Case Officer: Catherine Harker **Recommendation:** Approve

Applicant: WH Brakspear and Sons Ltd

Proposal: Part Retrospective update/refresh of the existing signage for The Lion. New external lighting fixed to the exterior of the building to replace brass swan-neck lighting installed without LBC (new lighting to replace the "swan necks" has not yet been installed)

South elevation fascia sign - 1 :10 scale

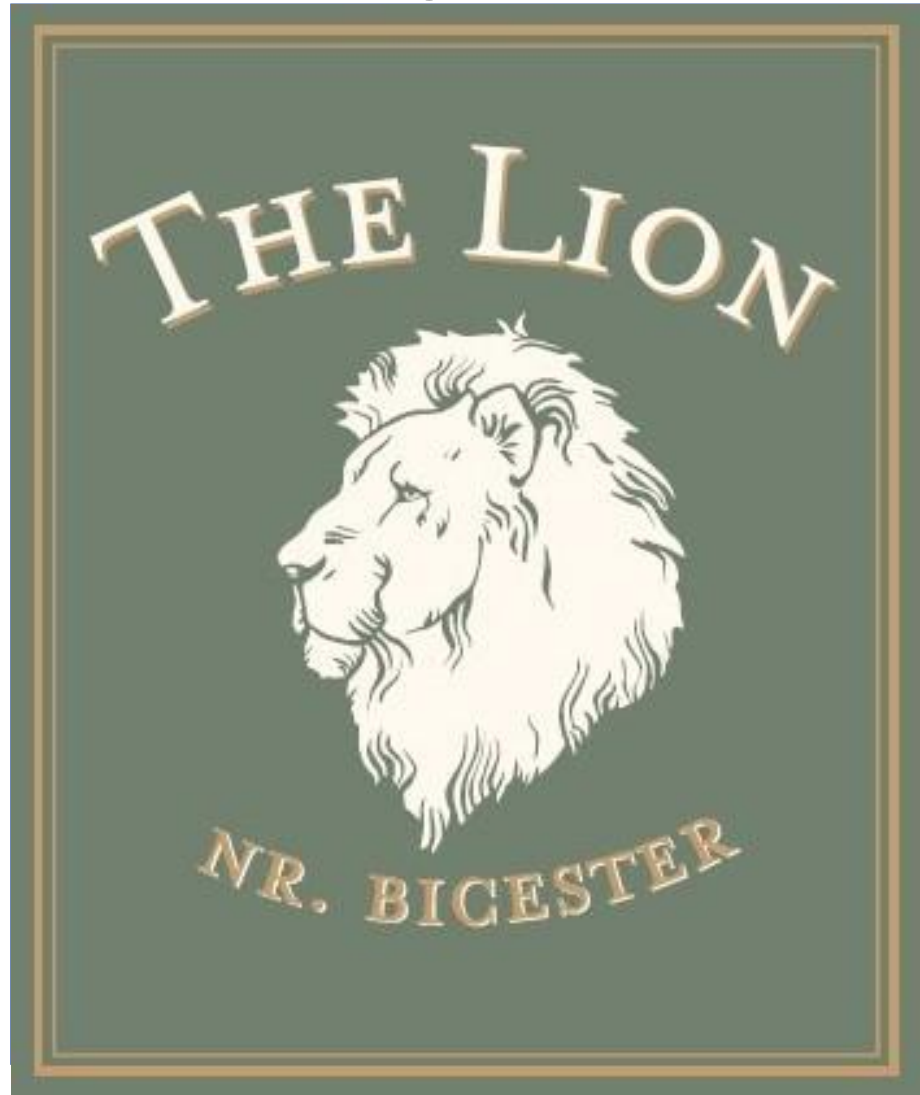
8.5. The new timber signs are considered to be of an appropriate material and colouring for a listed building, in accordance with the CDC Design Guide for Shop Fronts and Advertisements: Historic Buildings and Conservation Areas (2013) and although one of the signs is larger than previously, and slightly competes with the interesting historic first floor loading door on the south end elevation of the pub, it is not so large or obtrusive as to be harmful.
